CITY OF ALBUQUERQUE

PLANNING DEPARTMENT – Development & Building Services

RE: Mitchell Residence – Grading & Drainage Plan for Building Permit
2939 San Rafael S.E. P.E. Stamp 10/26/12 ~ File: **L16-D026**

<p style="font-size: 3em; font-weight: bold;">C-102</p>

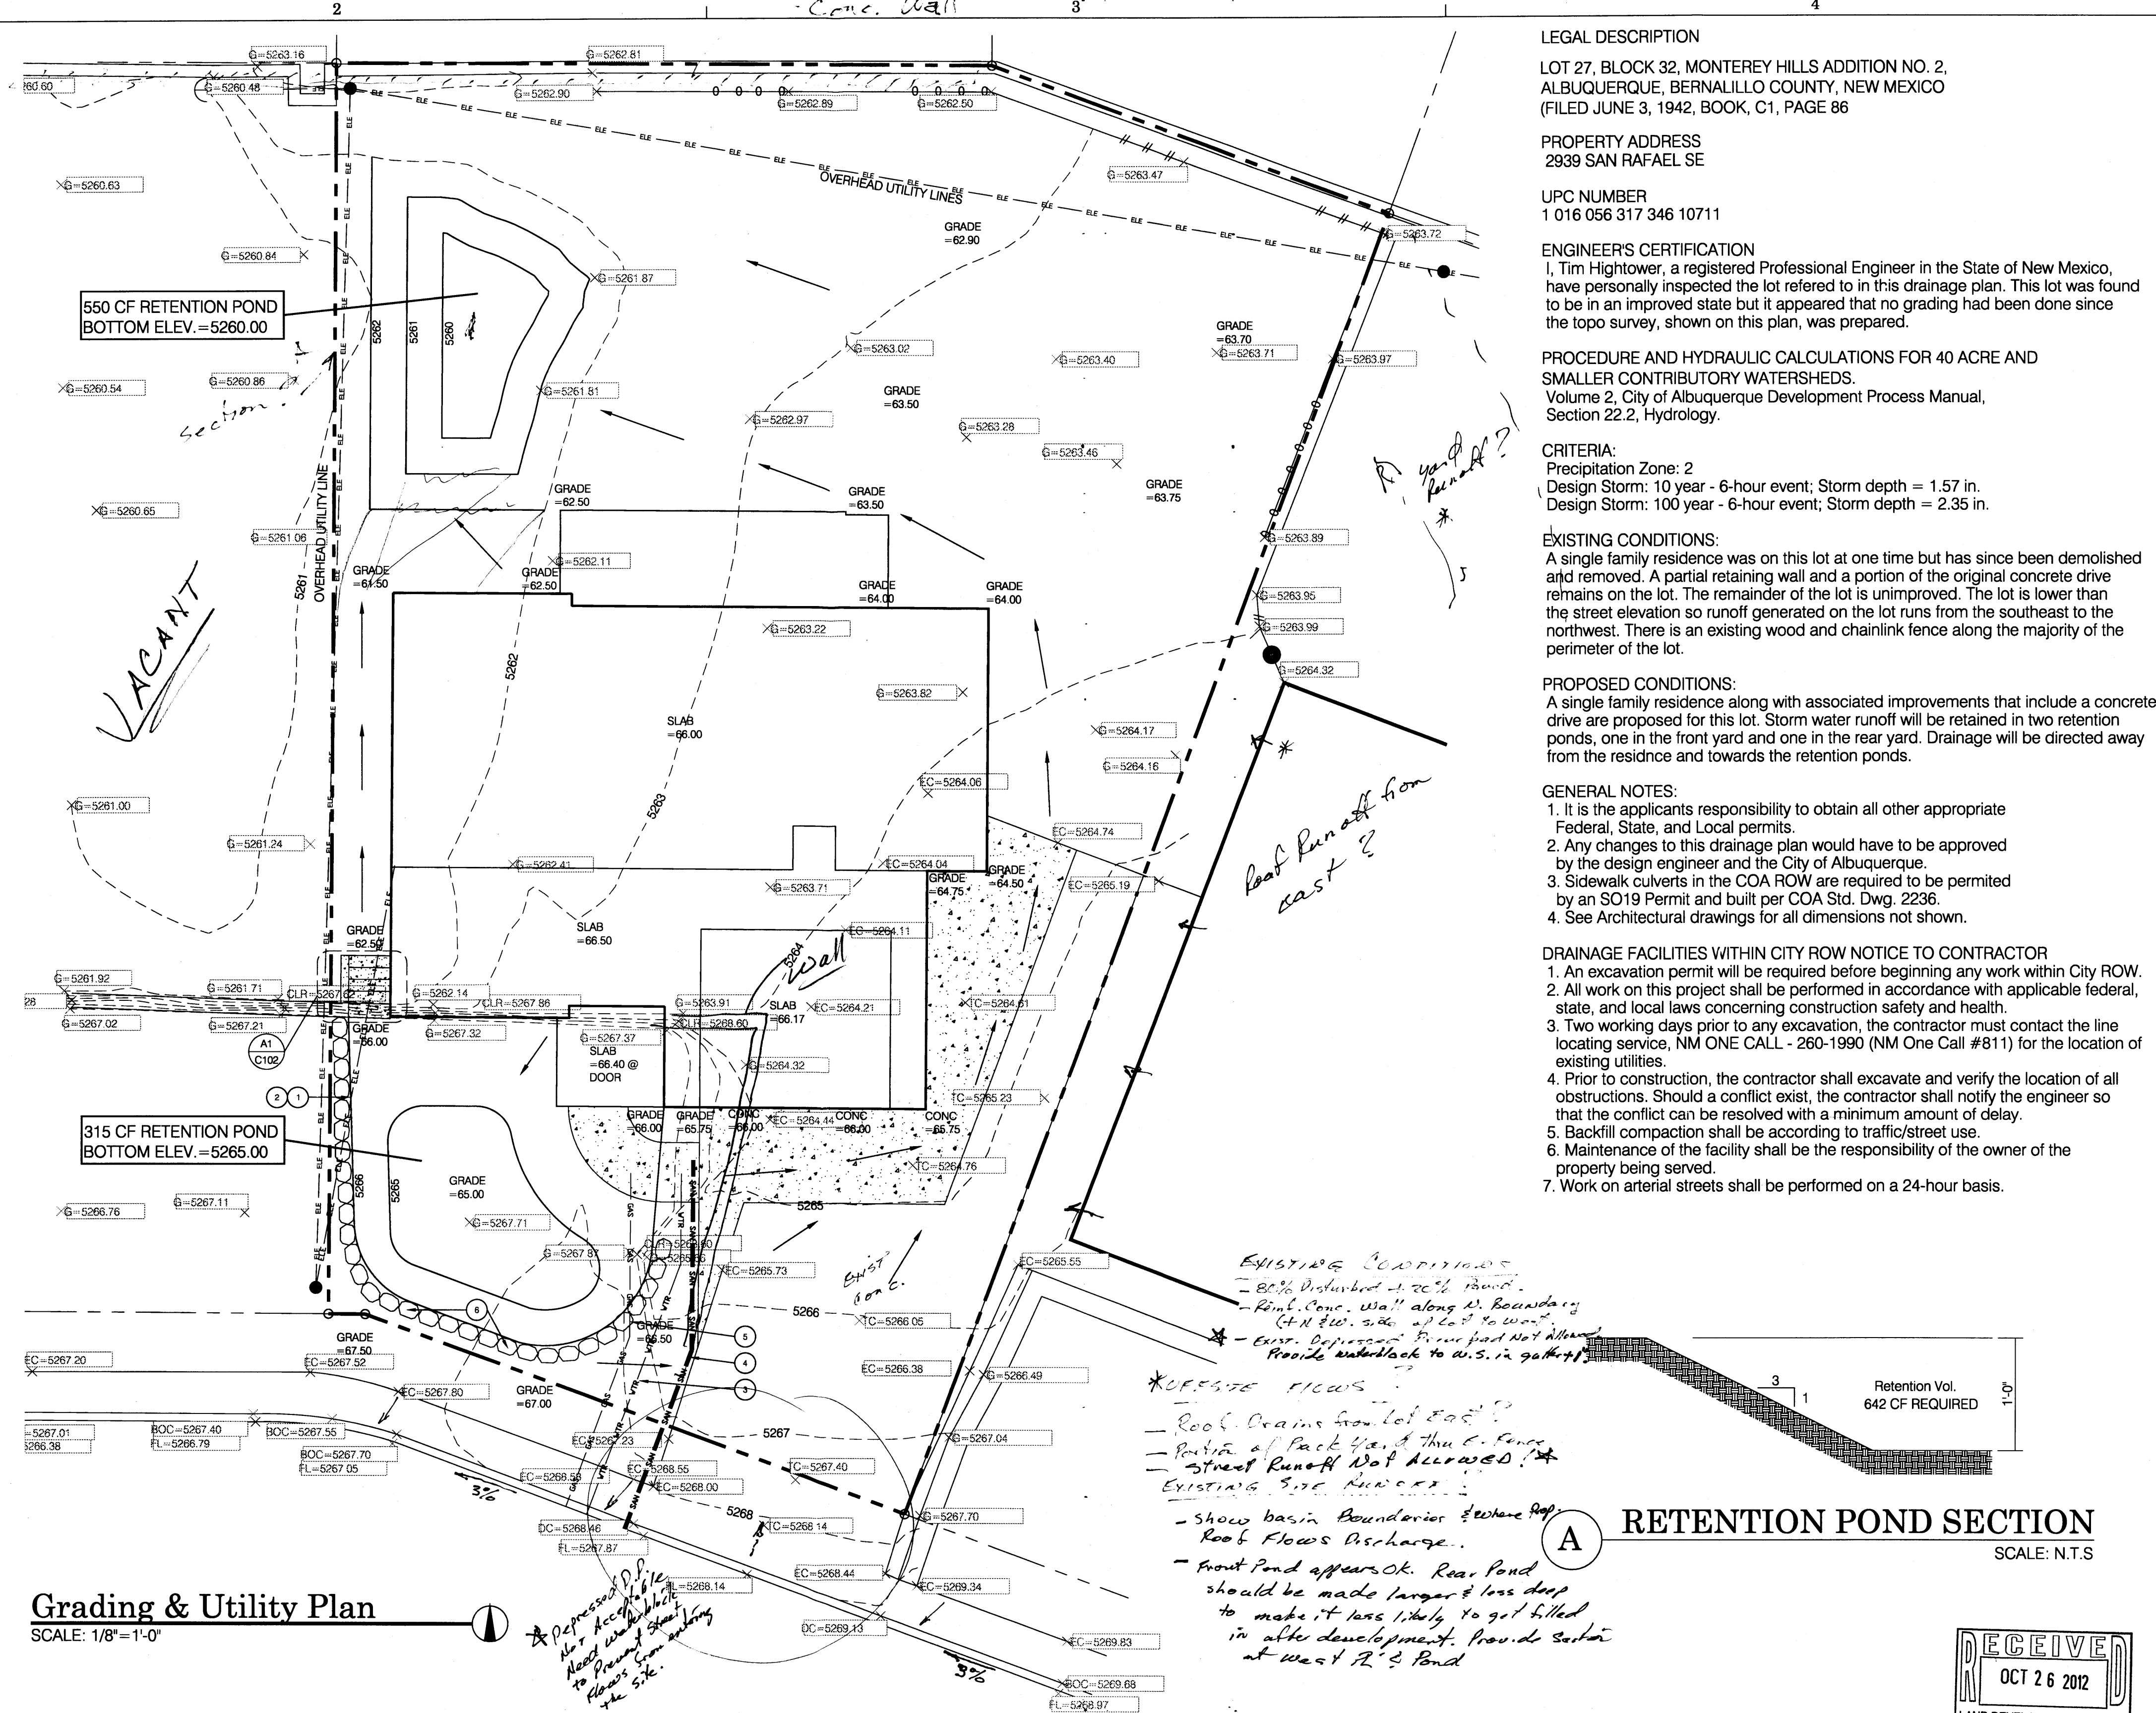
1. Per previous discussion with Curtis Cherne of this office, developed storm discharge from this site must be held to existing rates. Provide calculations of the existing, and estimates of offsite flows. Offsite flows appear to be possible from roof run-off from the existing building to the east, plus a portion of that back yard.

2. The plan does not reflect the existing concrete wall along the northern boundary, nor the extent of existing retaining wall (“L” shaped) near the center of the lot (image attached).

3. The plan needs to define drainage basins, and show where proposed roof runoff will discharge. The Drainage Calculation Summary needs to identify the basins, and include estimated offsite flows.

4. Revise the runoff calculations to reflect that the site was previously developed (Treatment B) and is currently partially paved (Treatment D).
5. The existing, depressed drivepad (sloping onto the site) is not acceptable. An adequate water-block must be provided to prevent street flows from entering this site. Our standard would be at least 8”, however if you can show that water depth in the gutter from the upstream street flows will be less than that, we will consider a water block of “water depth in the gutter” plus one-inch.

6. The proposed back yard pond is small and relatively deep. Our experience is that similar back yard ponds tend to be filled in by the property owners, subsequent to occupancy. As such, we require that the pond area be enlarged and the graded depth shallower so that it blends better with residential yard use, and is more likely to retain its required volume.

7. Provide a section at the west side of the back yard pond to verify how grading will fit existing contours without disturbing adjacent lot.
